Ribchester Parish Council

PLANNING APPLICATION No: 3/2017/0602

Application: Outline planning application for industrial units (classes B1, B2, B8) and associated access, landscaping and services infrastructure with all matters reserved except access. Change of use of farmhouse to office

At: **Higher College Farm, Blackburn Road, Hothersall**

Proposed Works To Junction (Corporation Arms)

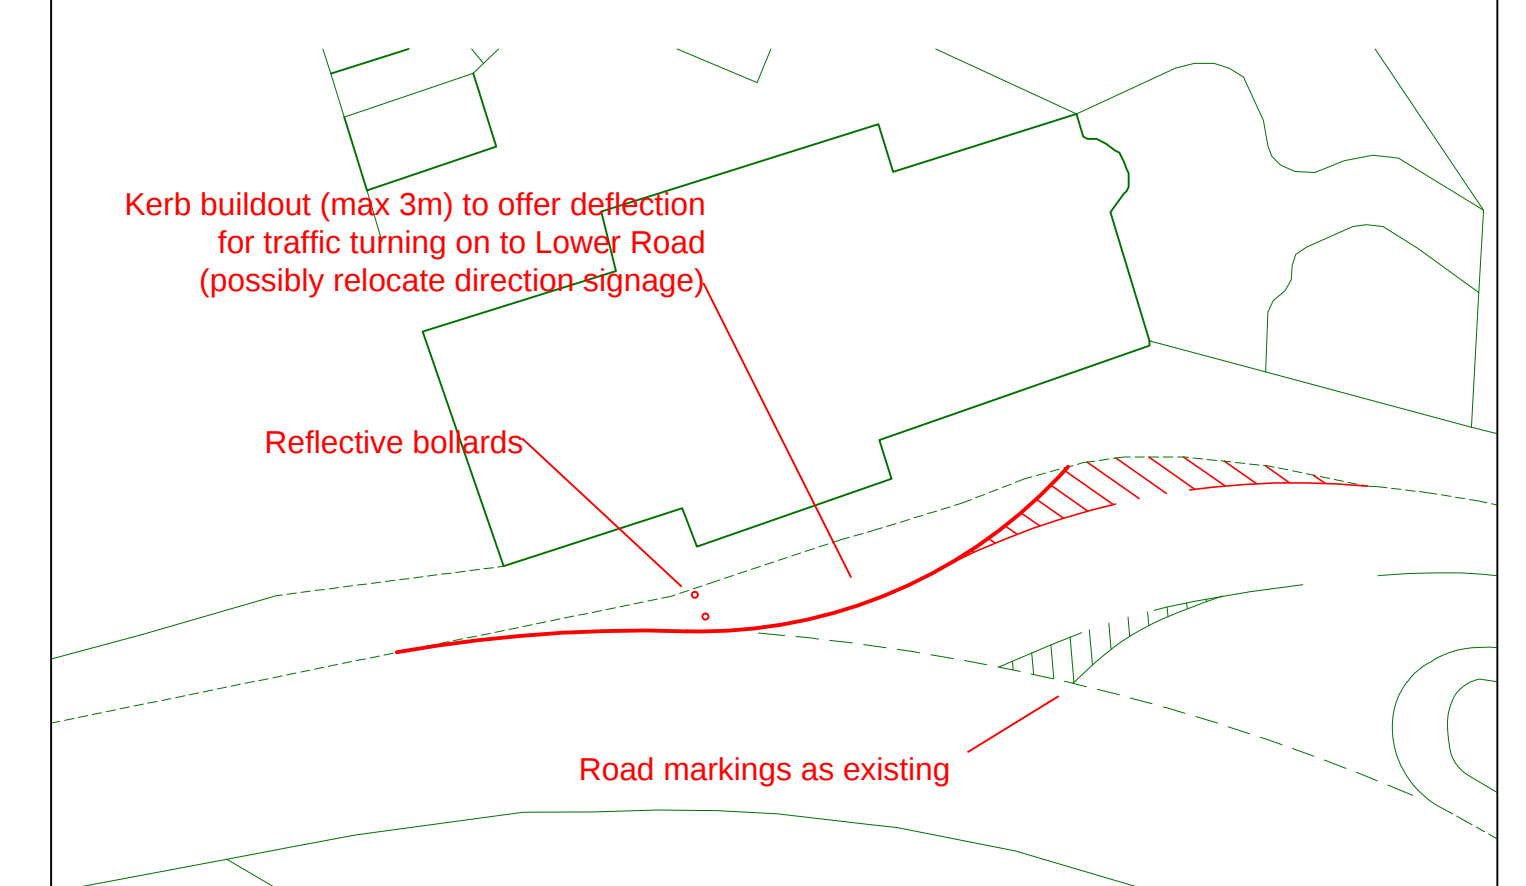
the high side and there have been a number of recorded accidents at the bifurcation by the Corporation Arms.
